**Consultation Response from KC,
Highways Development Management**

2025/90487 47, Huddersfield Road, Mirfield, WF14 8AE

Change of use and alterations to convert from vacant bank (Class E) to hot food takeaway (sui generis) with installation of extract and ventilation equipment and external alterations to the front and rear elevations

Date Responded: 8-5-2025.

title  
**Proposed**  
Ground Floor Layout

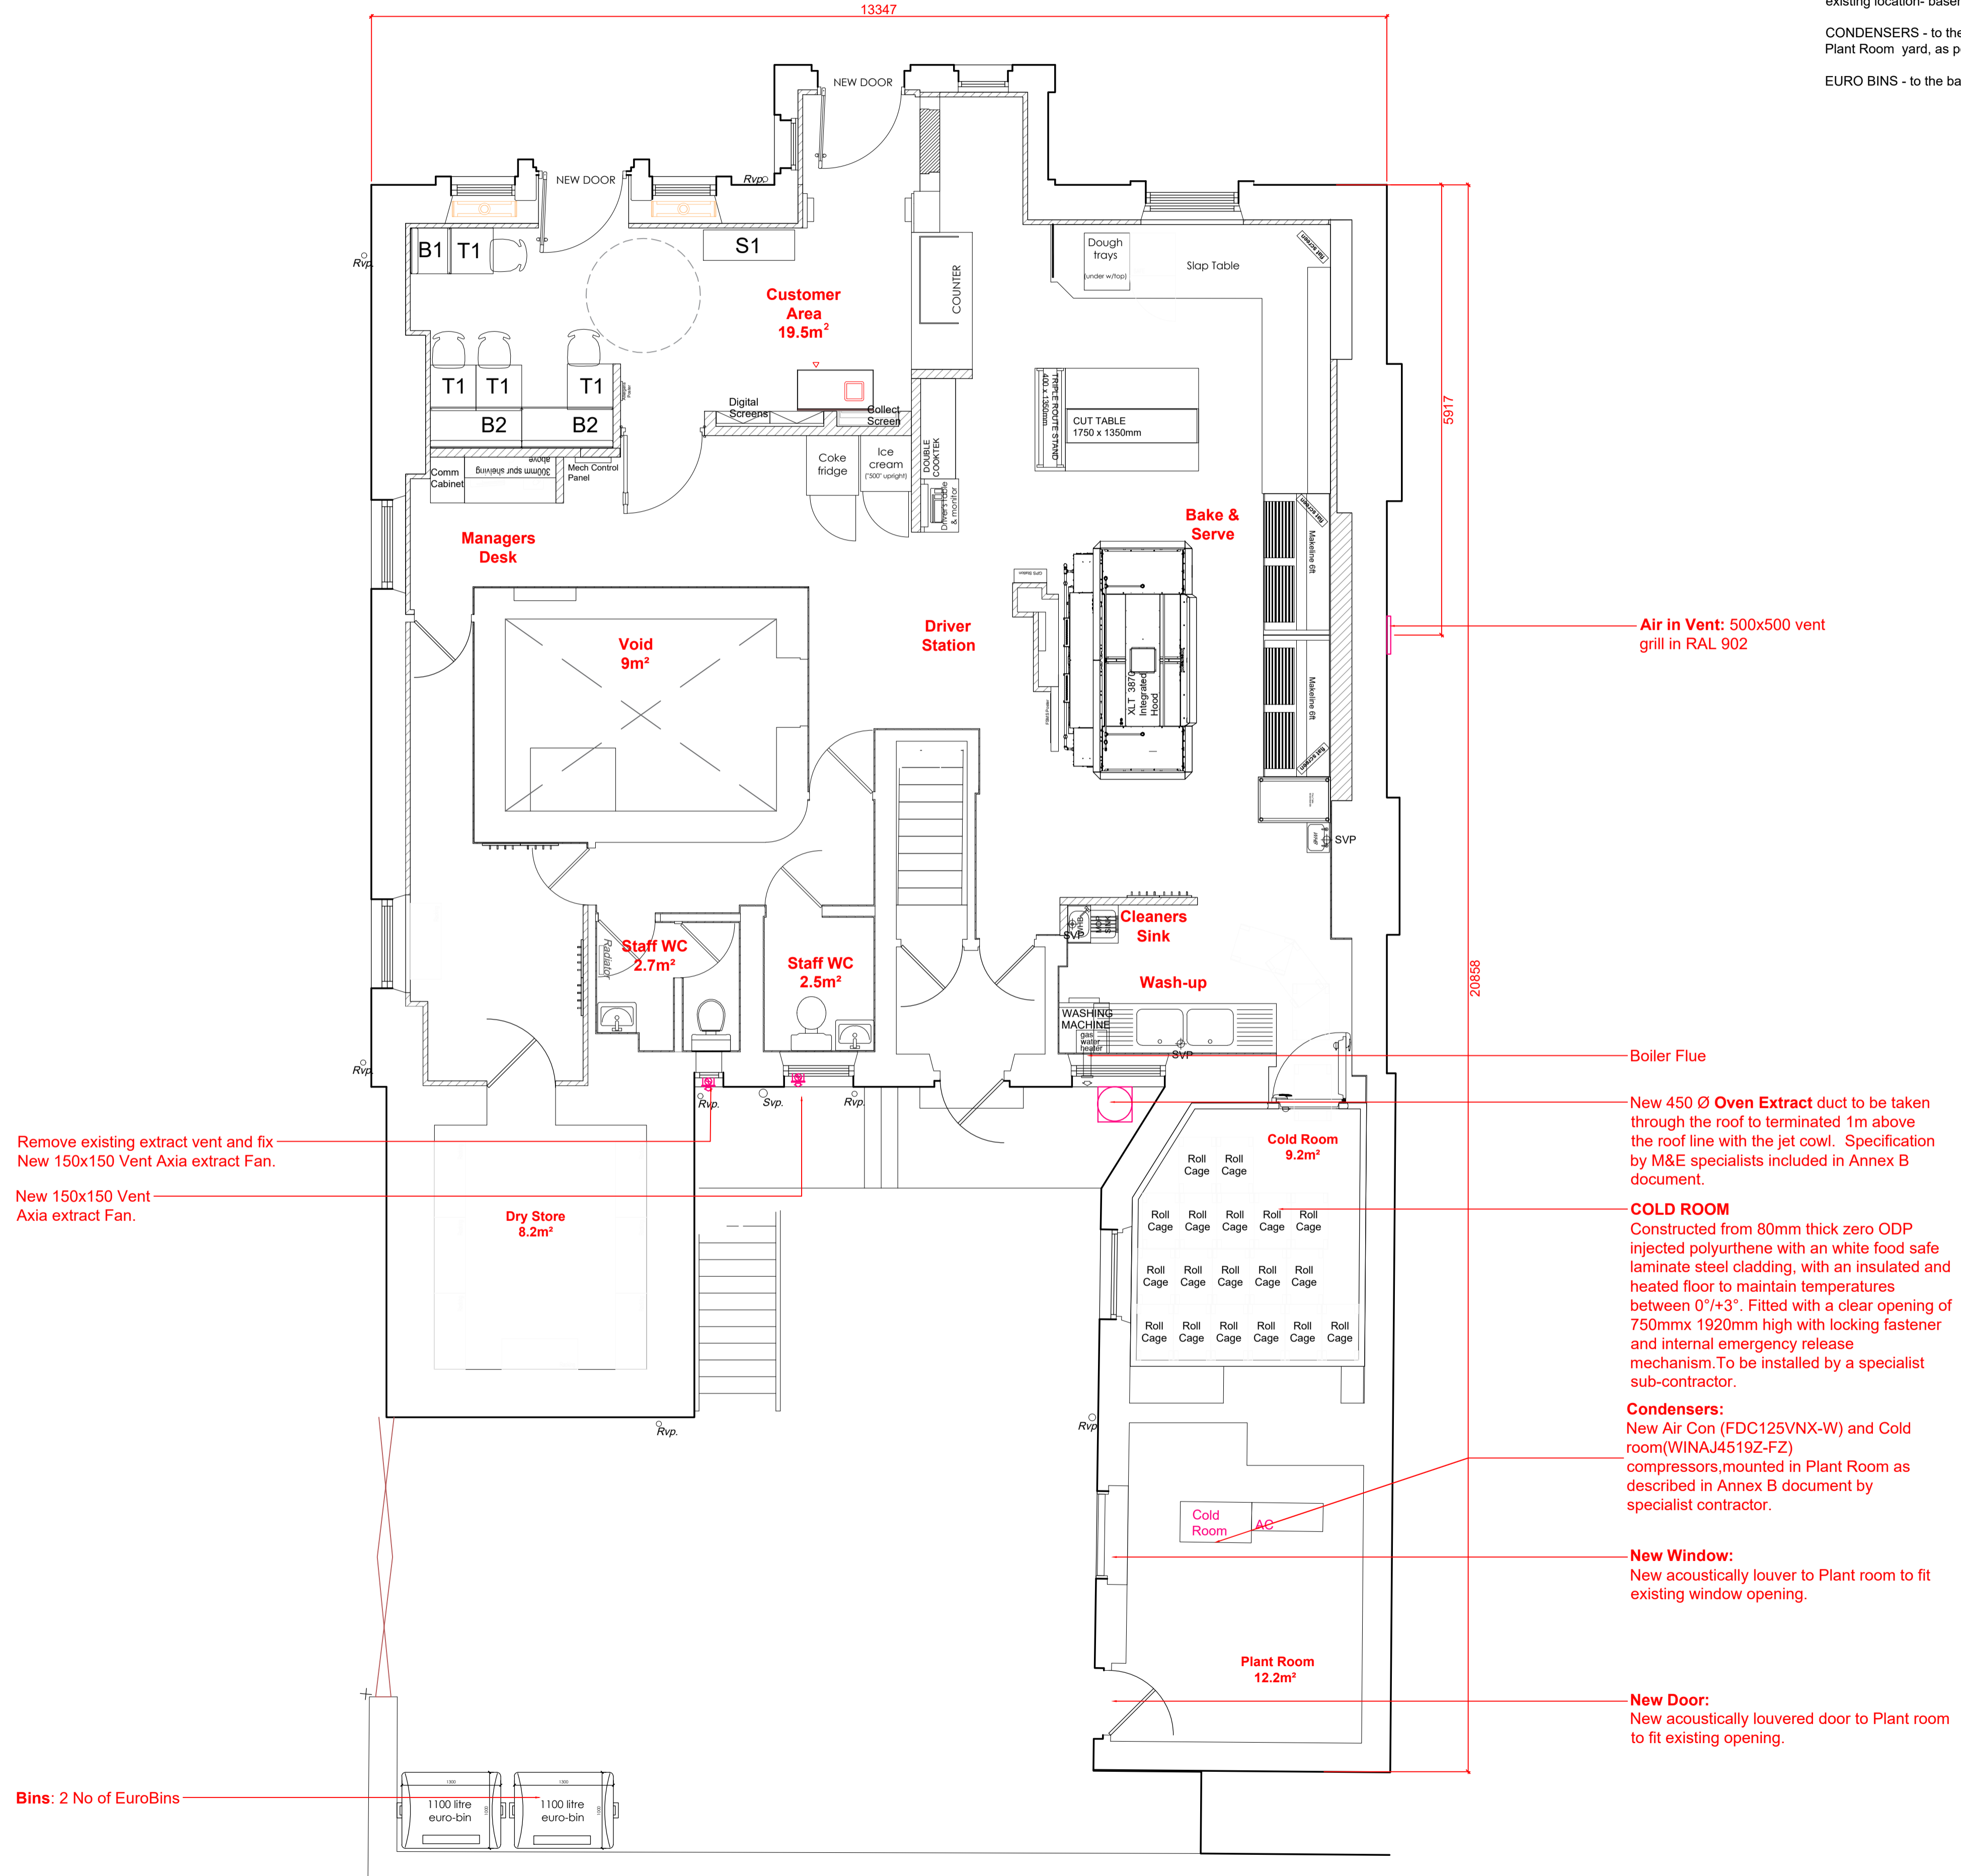
Is number 1 at the rear a domestic property? If it is, then bin storage against this property would be a fire risk for residents – especially if there are windows to that elevation - so either the bins need to be stored 6m away from any building, or they need some form of fireproof enclosure/cover.

Bin collection is proposed from the front of the site, but no details are provided. More bins may be needed than the 2 specified on the plans and in the Waste Management Plan.
